REQUEST FOR SEARS
DOOLEY'S LIDCOMBE CATHOLIC CLUB - SSD 7603
AUBURN COUNCIL COMMENTS

Thank you for the opportunity to comment on the draft SEARs for the Dooley's Lidcombe Catholic Club proposal SSD 7603. Council's comments are outlined below in the same structure as the Draft SEARs.

Hotel & Tourist Related Development – Dooleys Lidcombe Catholic Club (SSD 7603) Request for Secretary's Environmental Assessment Requirements

1 MASSING - NE VIEW

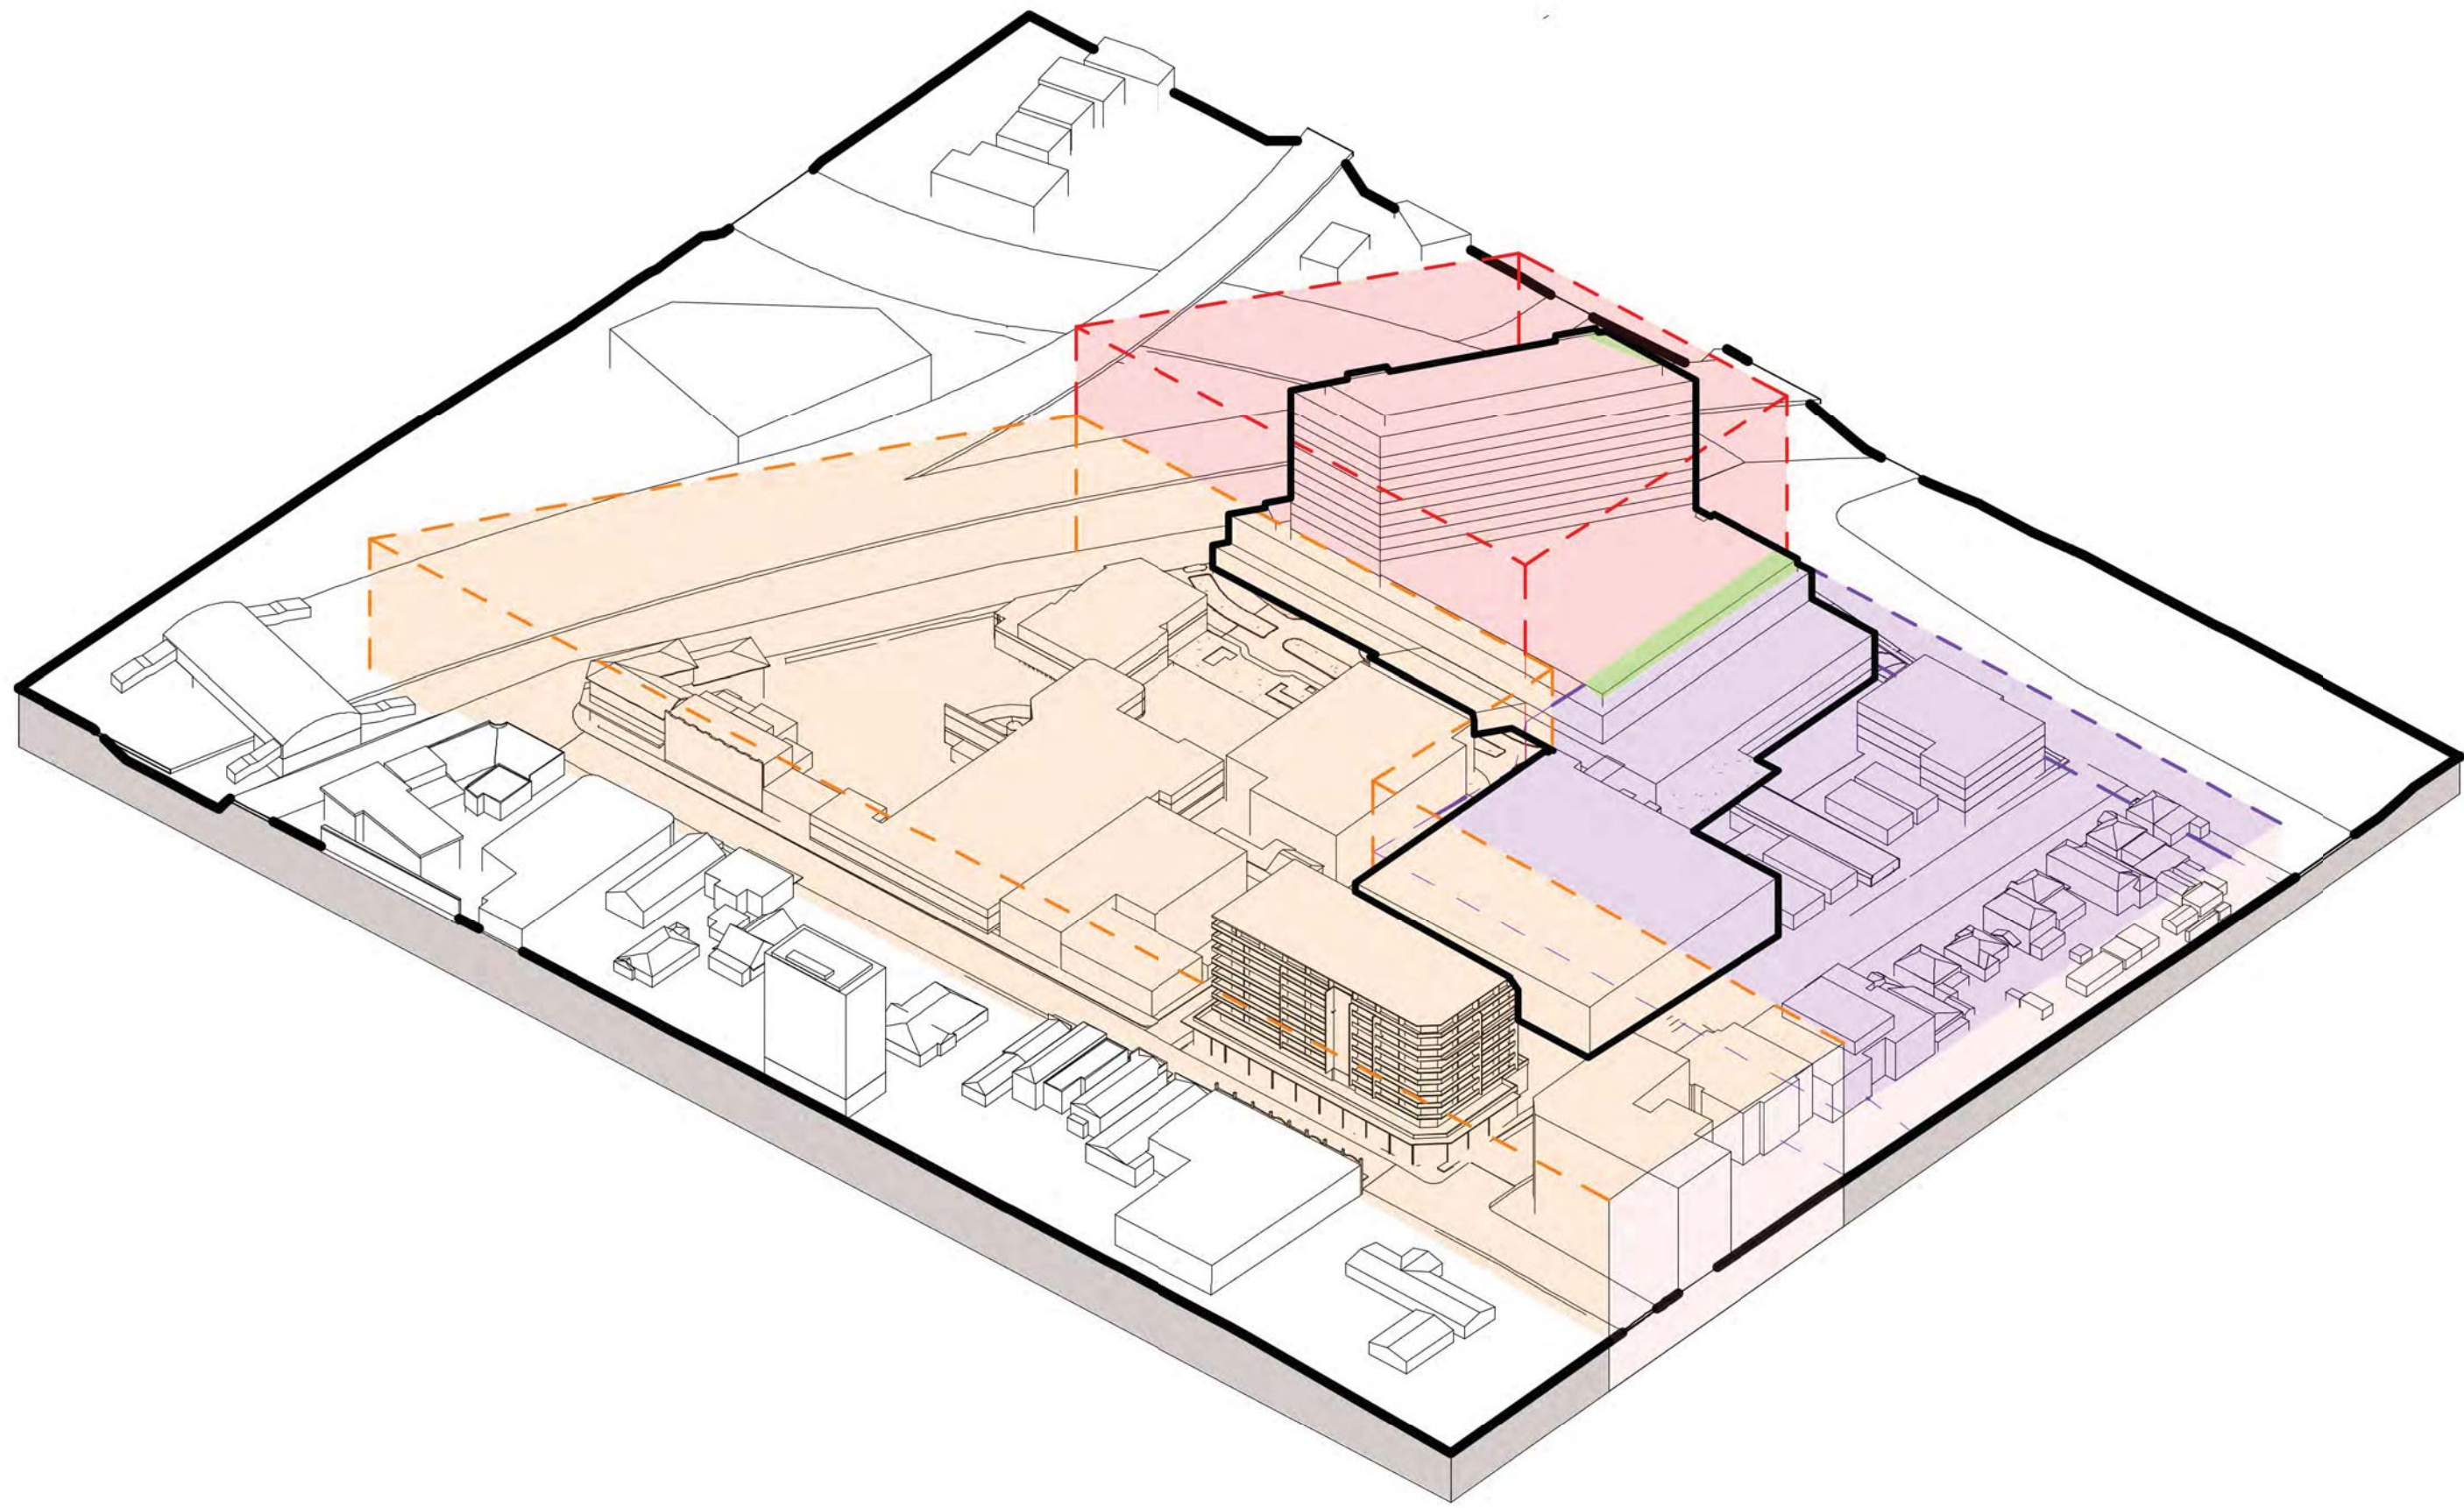
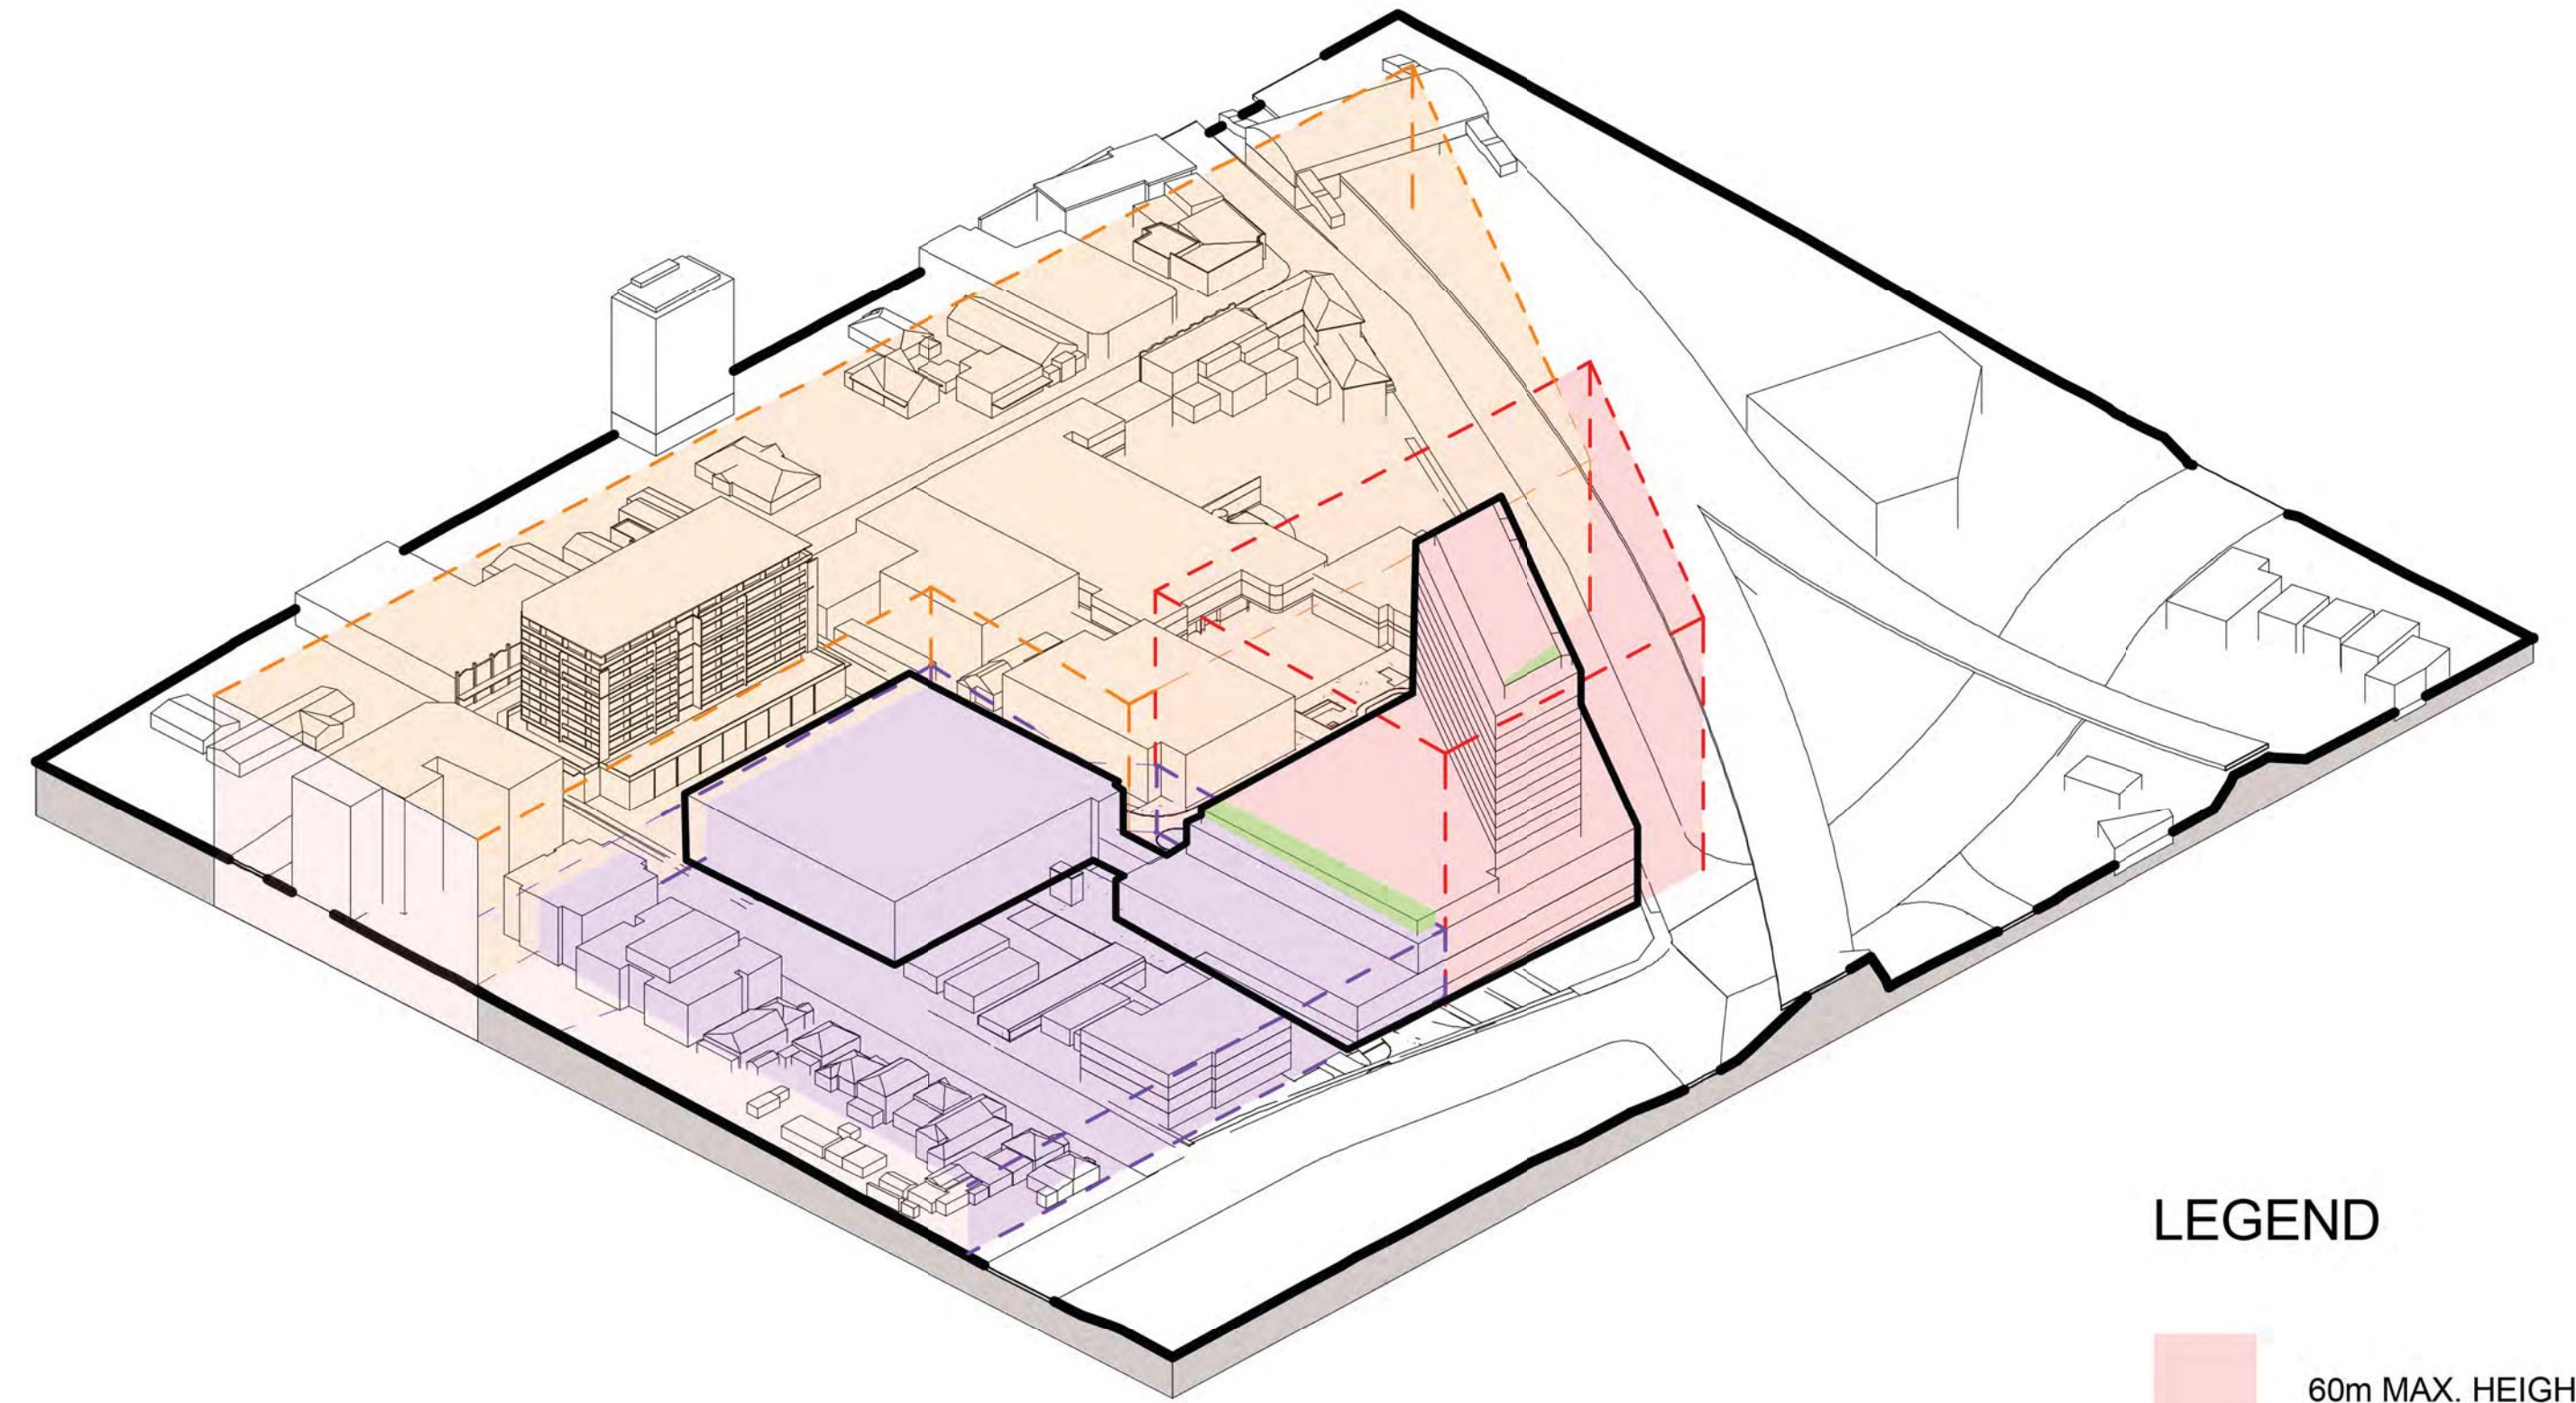
- Though it is not possible to determine the actual length of the hotel tower, it appears very long. Consideration should be given to breaking it up to reduce the apparent bulk and scale.
- All non-compliances with height and FSR should be adequately justified. The stated FSR seems very low for a proposal that includes a 60m high building. FSR calculations need to be shown.
- Further consideration as to the floor space ratio and determination of “site area” applying to the R4 zoned portion of the land is required. Clause 4.5(4) nominates that land on which the proposed development is prohibited is to be excluded from site area. This may have ramifications in terms of determining an overall FSR for the proposal.
- Note that any parking above the requirements contributes to the FSR (see definition of FSR in Standard Instrument).
